Subject: Shoreline Exemption Permit, Pump Station 18 – 7220 Holly Hill Drive.

This is a written response to the review comments provided by the Community Planning and Development Department regarding the application for the Shoreline Exemption Permit, SHL23-009, for Pump Station 18 located at 7220 Holly Hill Drive.

PUMP STATION 18 - 7220 HOLLY HILL DRIVE

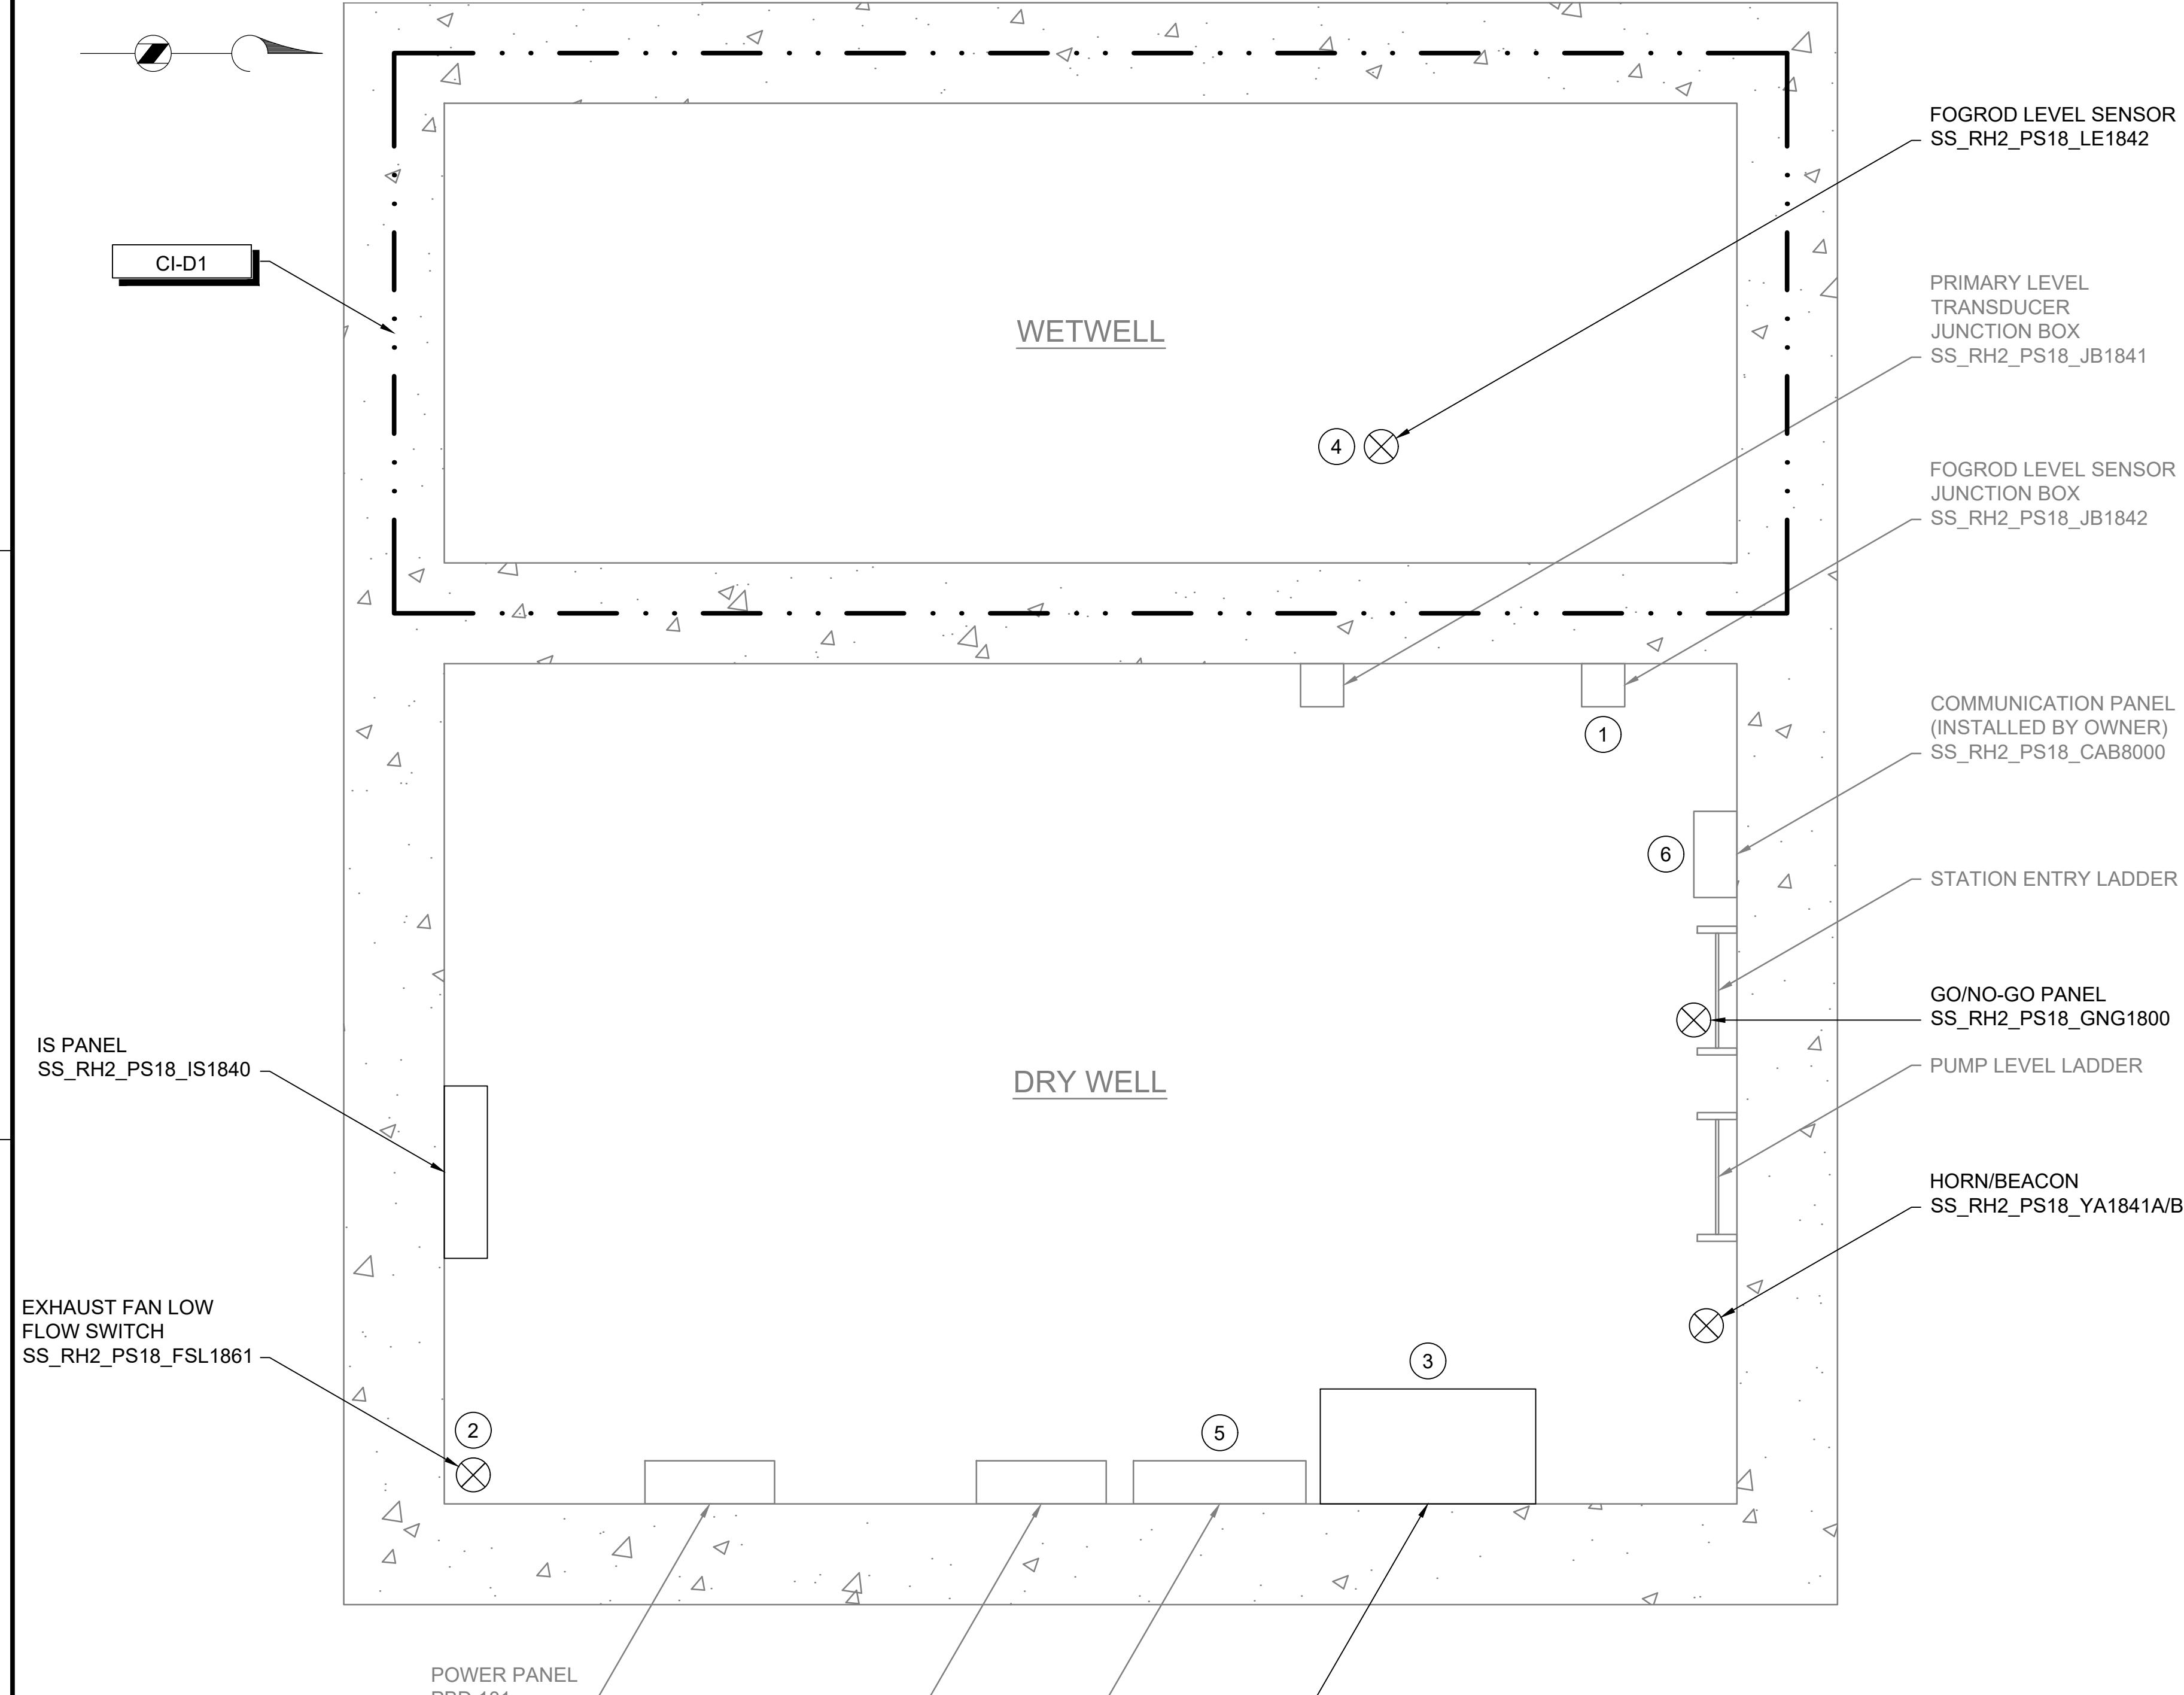
- a. Provide address of all pump stations on plans

**Response:** *The address for the pump station has been added to Development Plan, Instrumentation Drawing page 1. The address was also included in the aerial photo of the pump station.*
